CITY OF ALBUQUERQUE

March 26, 2018

Re: Enchantment Carpets
4815 Mcleod Rd. NE
Traffic Circulation Layout
Architect's Stamp **03-19-18** (F17-D099)

AS-1.0

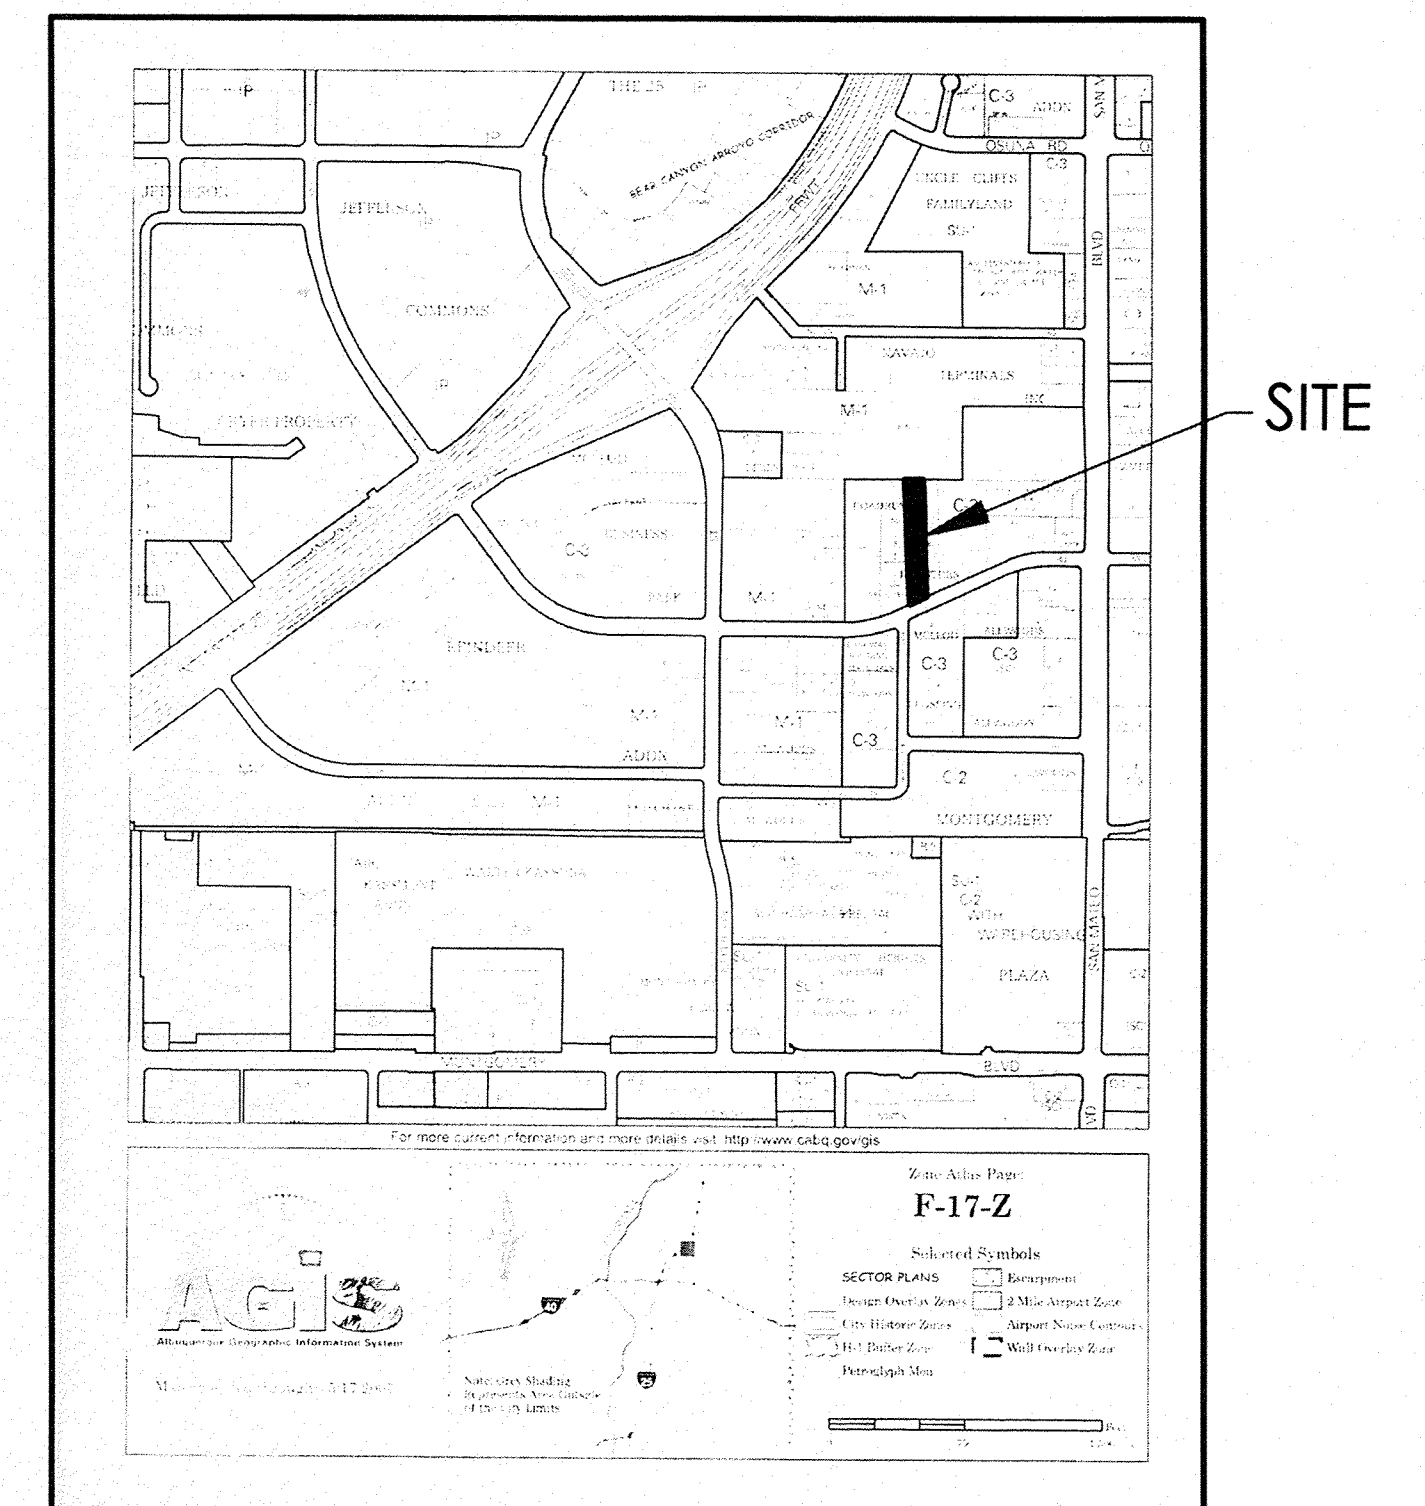
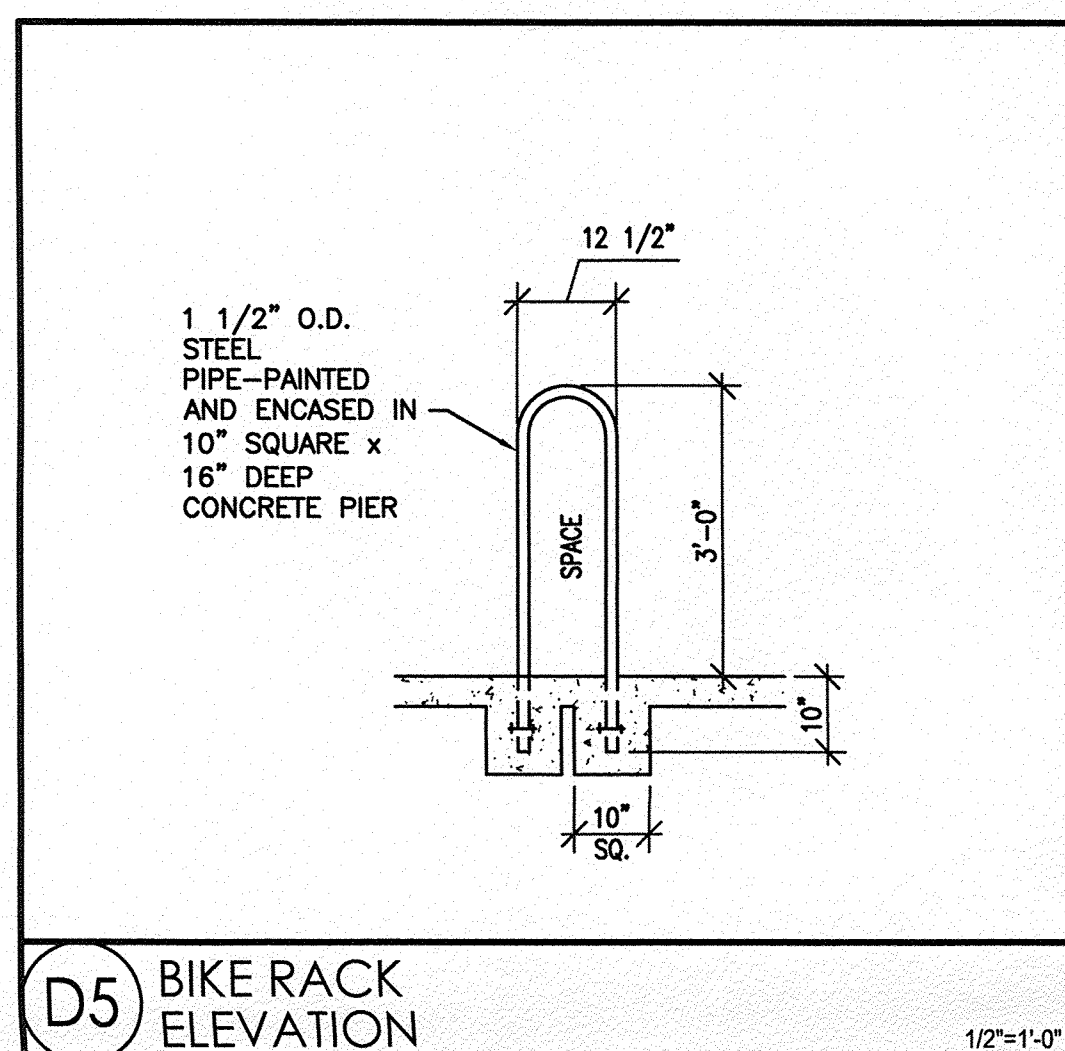
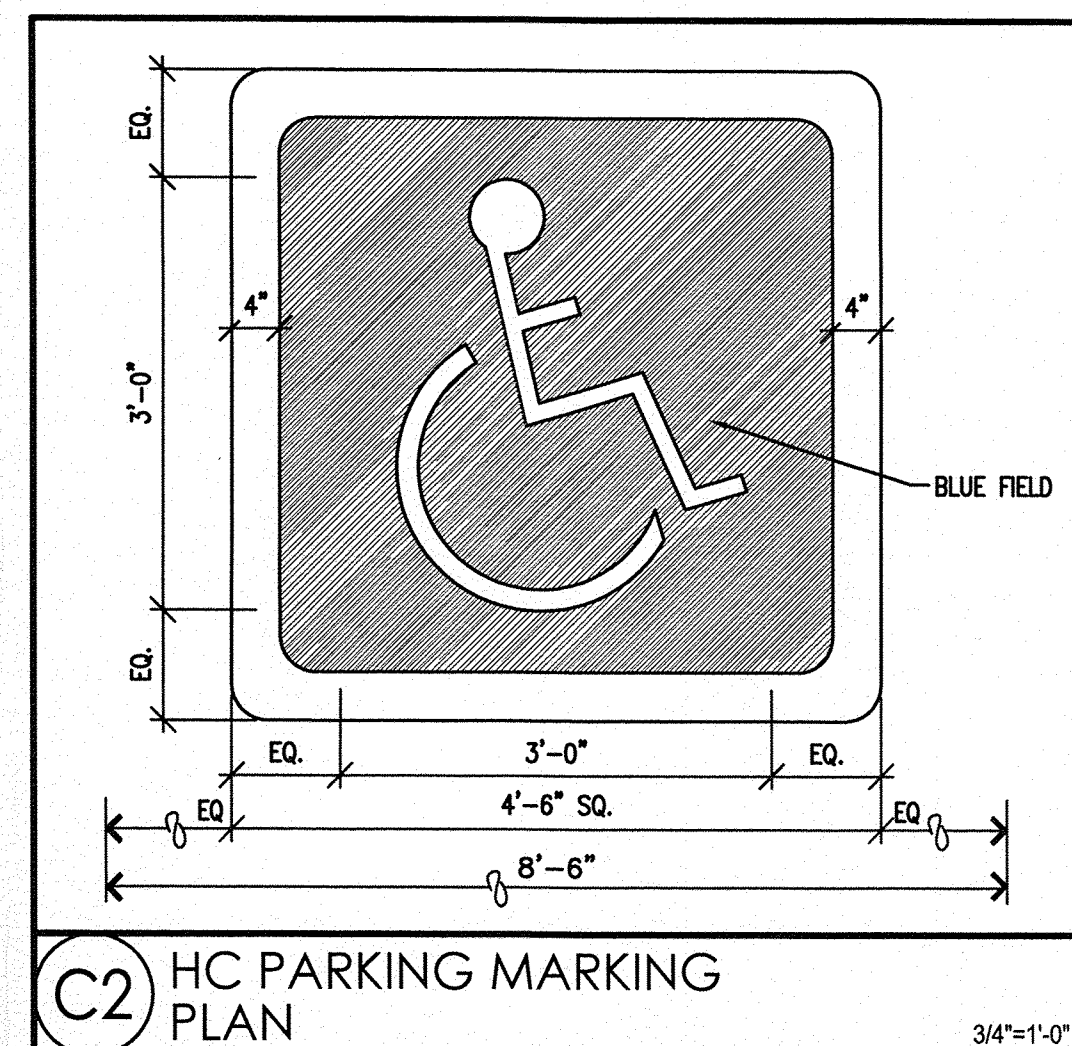
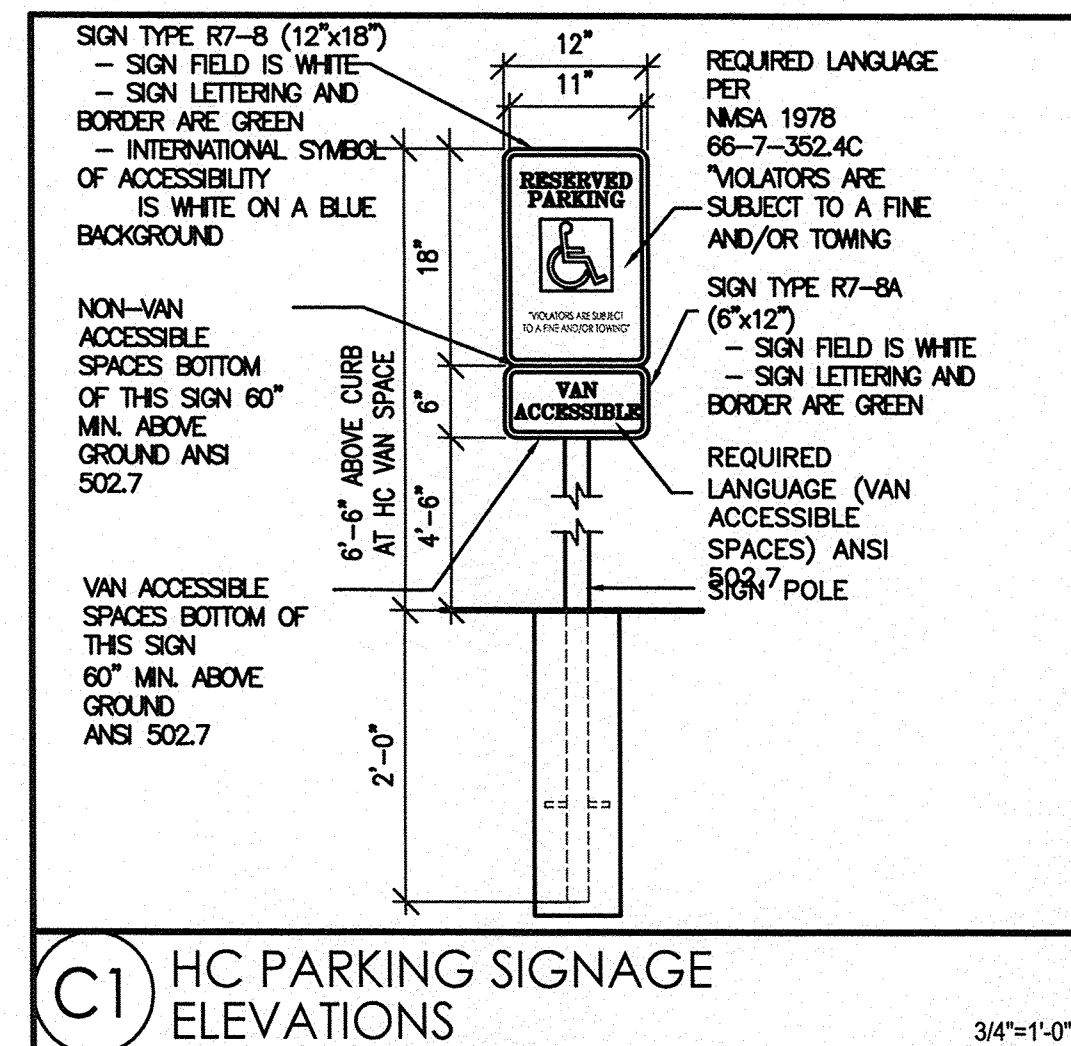
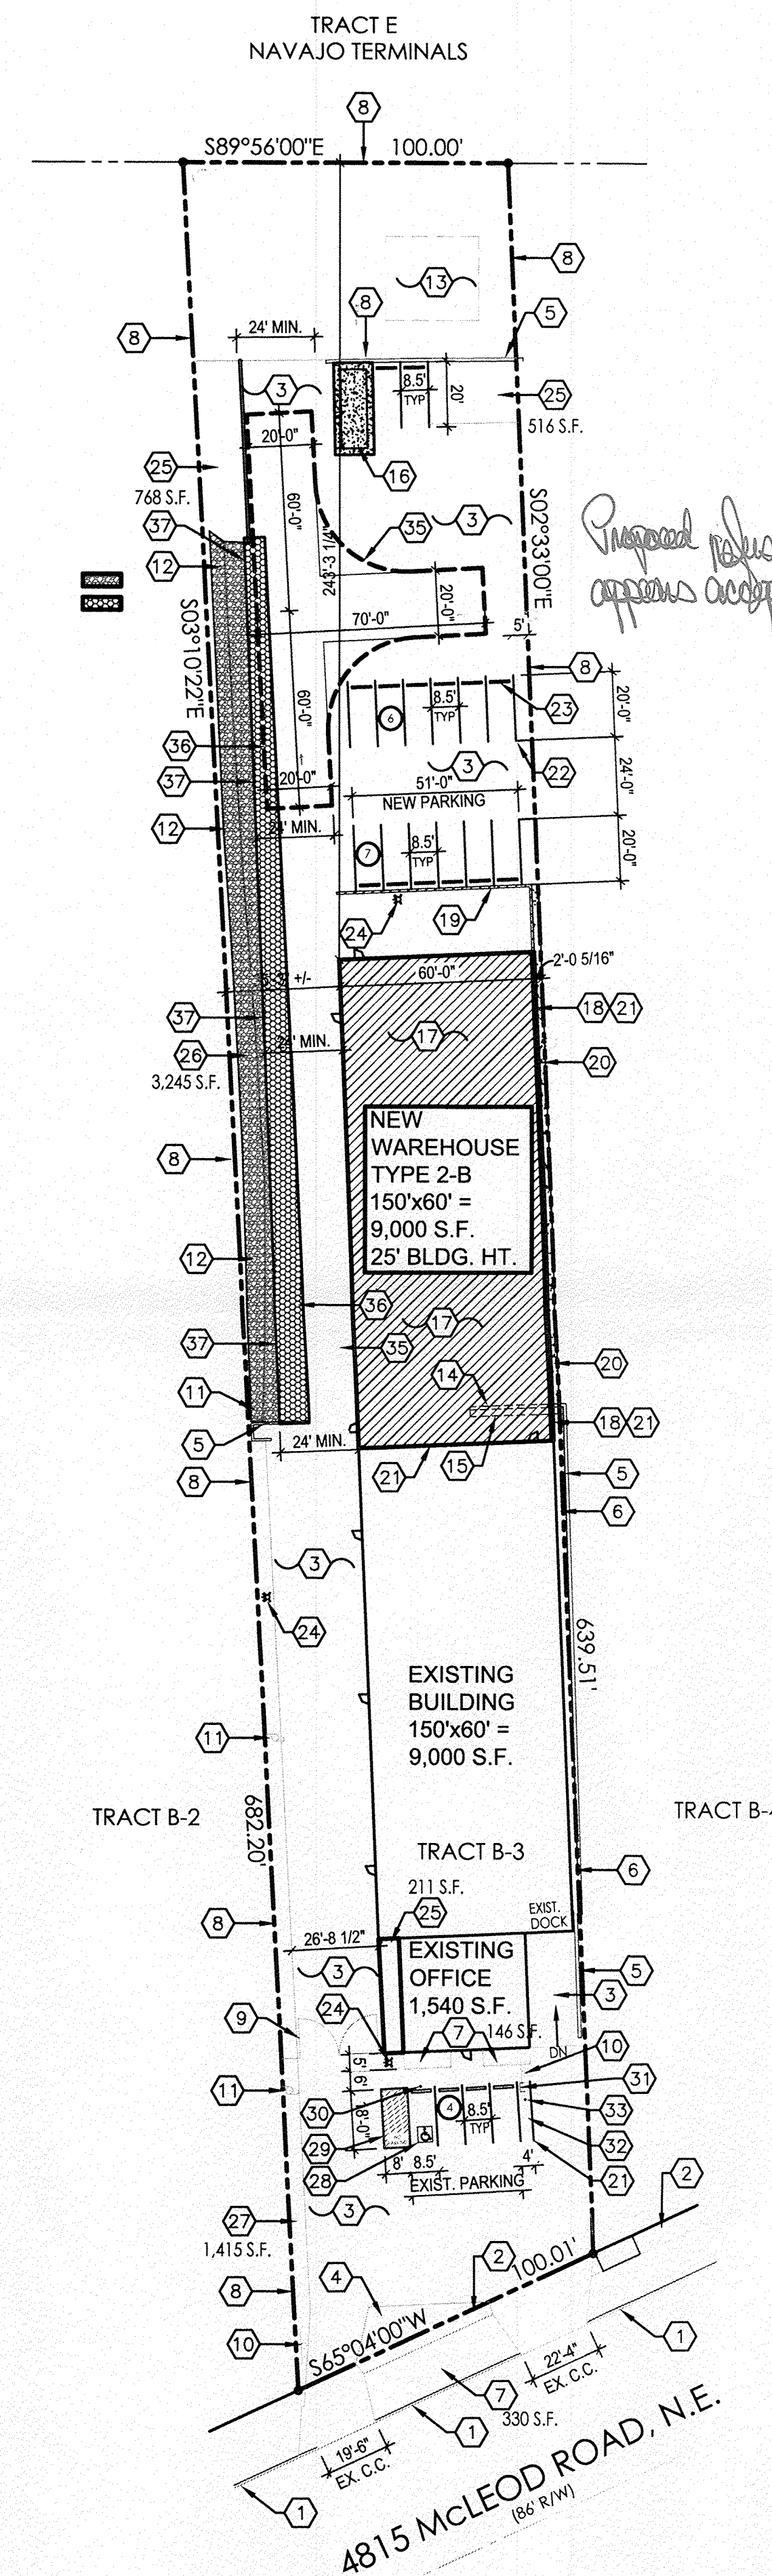
1. Service vehicle and/or refuse vehicle maneuvering must be contained on-site; provide a copy of refuse approval.
2. Please show the location of the bicycle rack.
3. Please provide a legend clarifying what the hatching locations indicate.
4. Provide slope information in the drainage feature. Do vehicles need to be protected from this area?
5. 24 feet is required for two-way vehicular traffic.
